Recommendation Report for Planning Permission for Works or Extension to a Dwelling

REF NO: R/89/22/HH

LOCATION: 75 Chaucer Avenue
Rustington
BN16 2PG

PROPOSAL: Single storey rear extension and conversion of loft to habitable use including the installation of 1 x rear dormer and 3 x front rooflights.

Drawing Title:
PROPOSED FLOOR PLANS

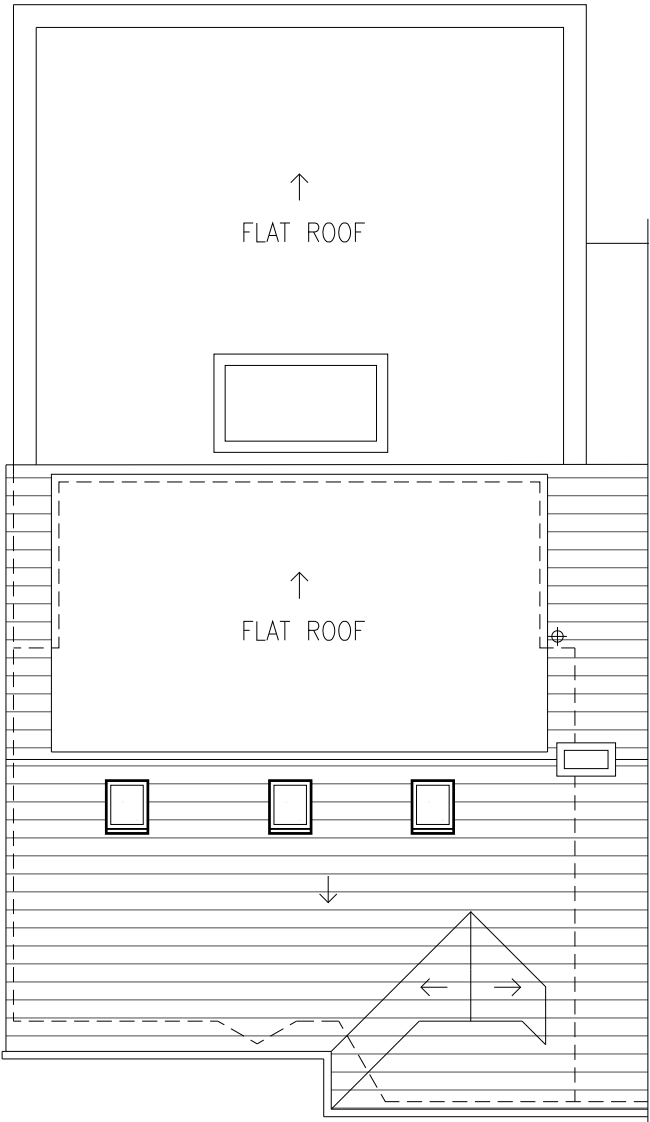
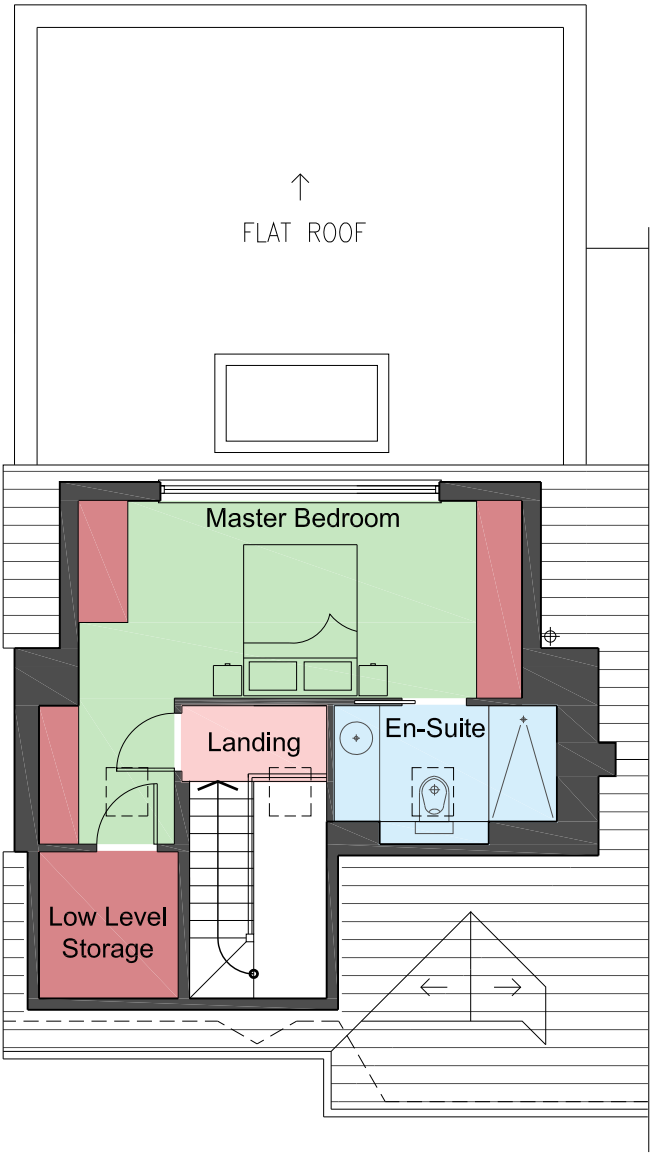
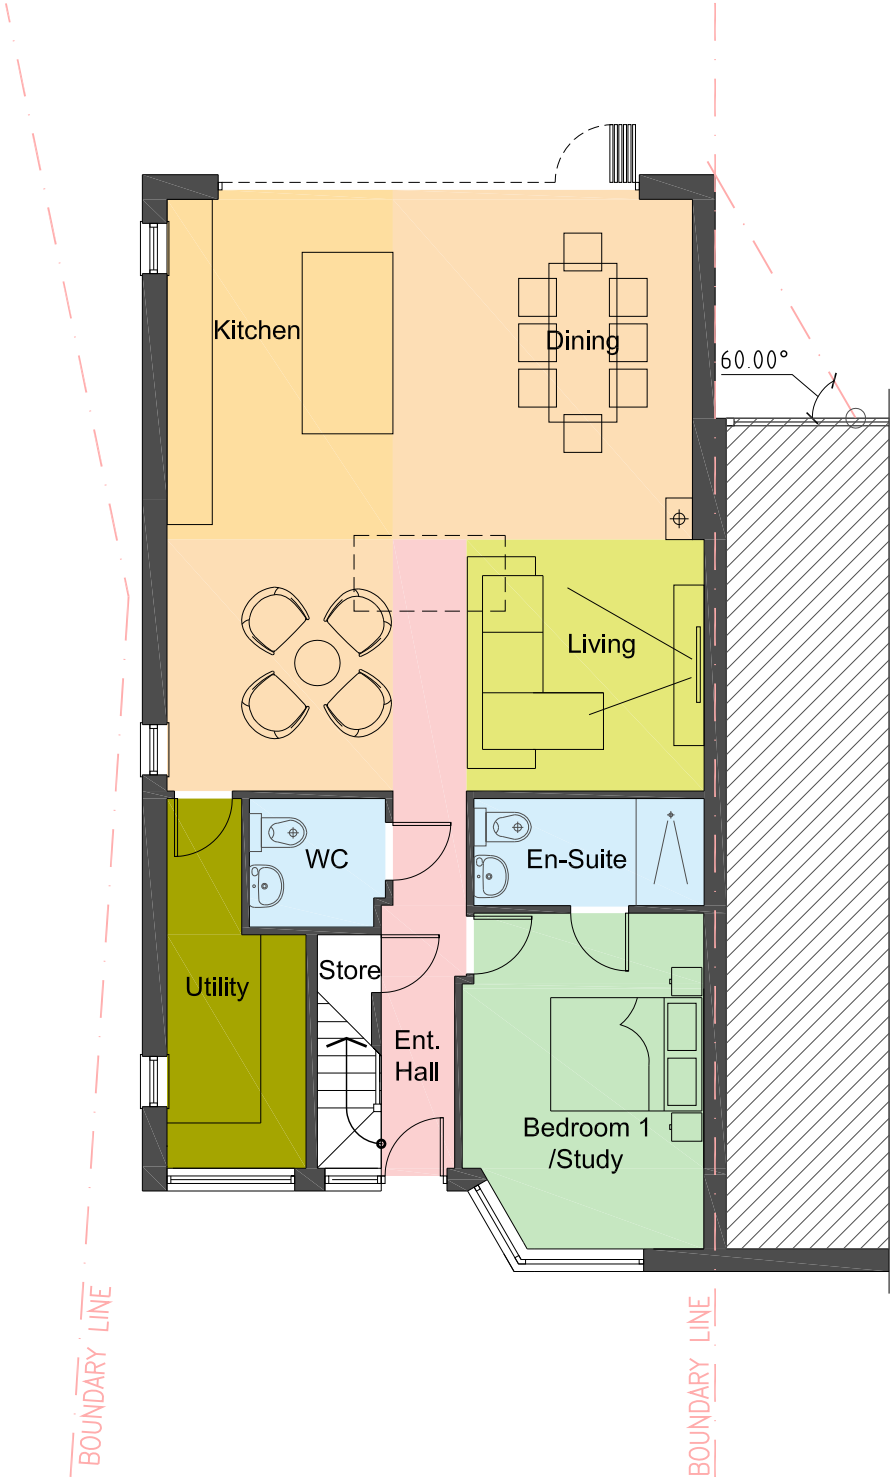
During the course of the application the applicant has reduced the length of the extension so that it now accords with the 60-degree rule for rear extensions and will retain a garden length above the level the Design Guide recommends. The ground floor footprint will encroach by approx. 500mm on its northern boundary; however, the existing arrangement is also closely positioned so no excessive overbearing effect will take place.

Drawing Title:
PROPOSED ELEVATIONS

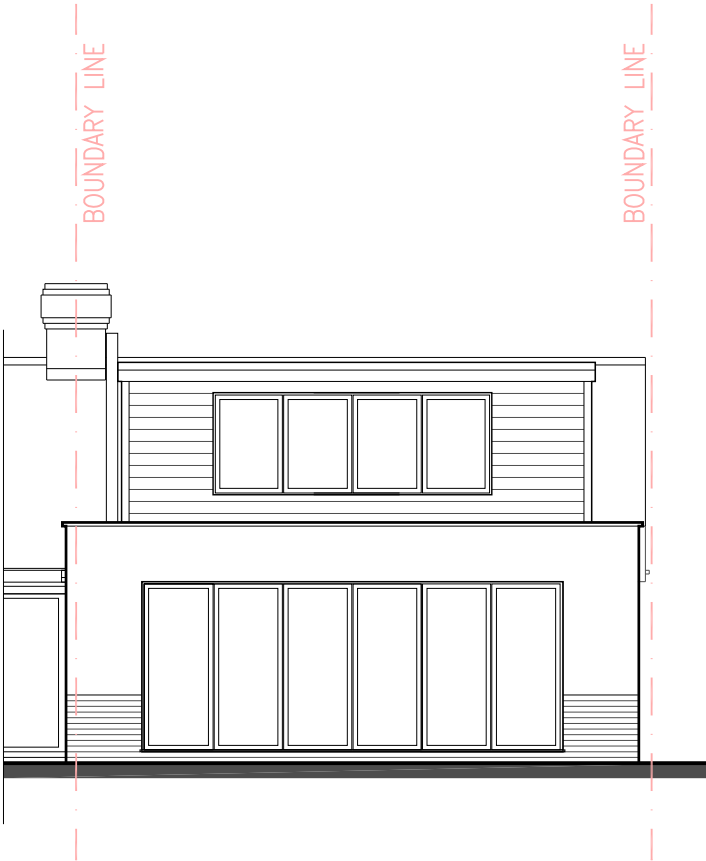
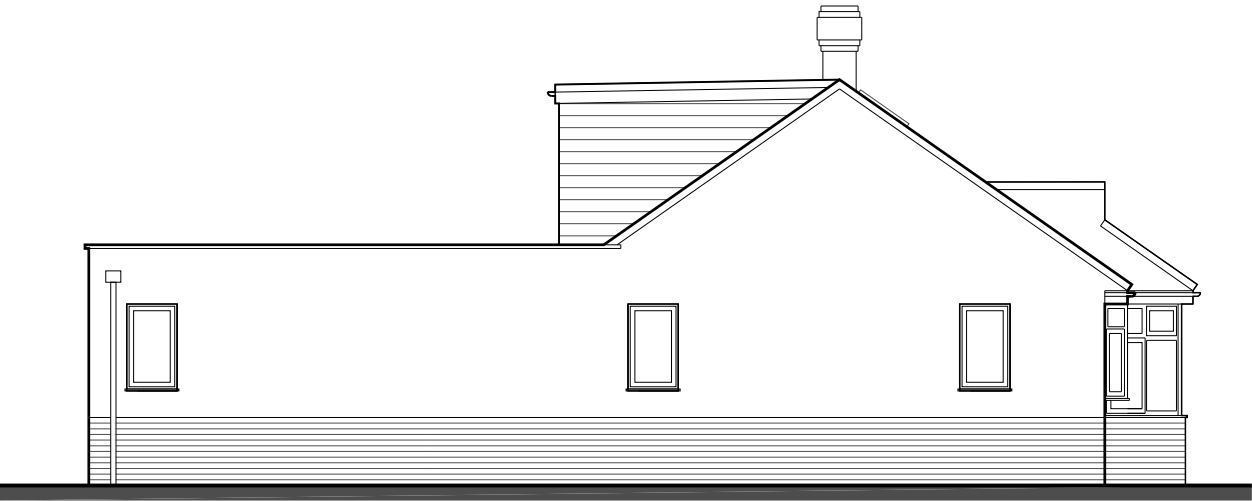
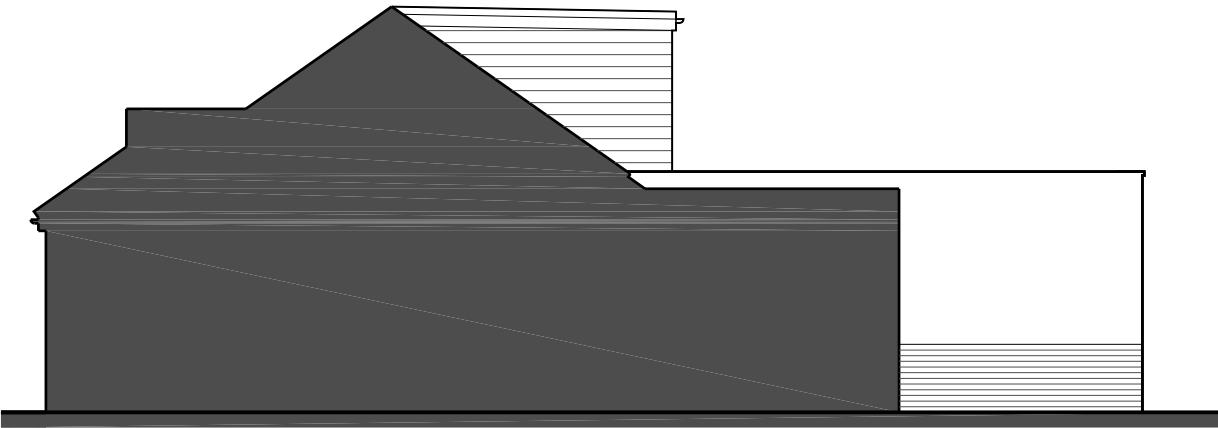
Design guidance states that dormers positioned to the rear of properties are more appropriate so that they do not provide excessive visual intrusion, and as a form of development are beneficial as they make an effective use of a plot. It also stipulates that extensions to roofs should be built to match the existing roof in pitch and materials. The proposed extensions to the roof accord with this guidance.

The proposal introduces windows to the rear and front elevation at first floor level, all other proposed windows are to the ground floor. Comments have been received relating to potential overlooking to the front from the rooflights. All views achieved, front and back above ground floor level, are compliant with guidance in that the separation gap between overlooking windows is over 21m. Therefore, no negative impact from overlooking will occur.
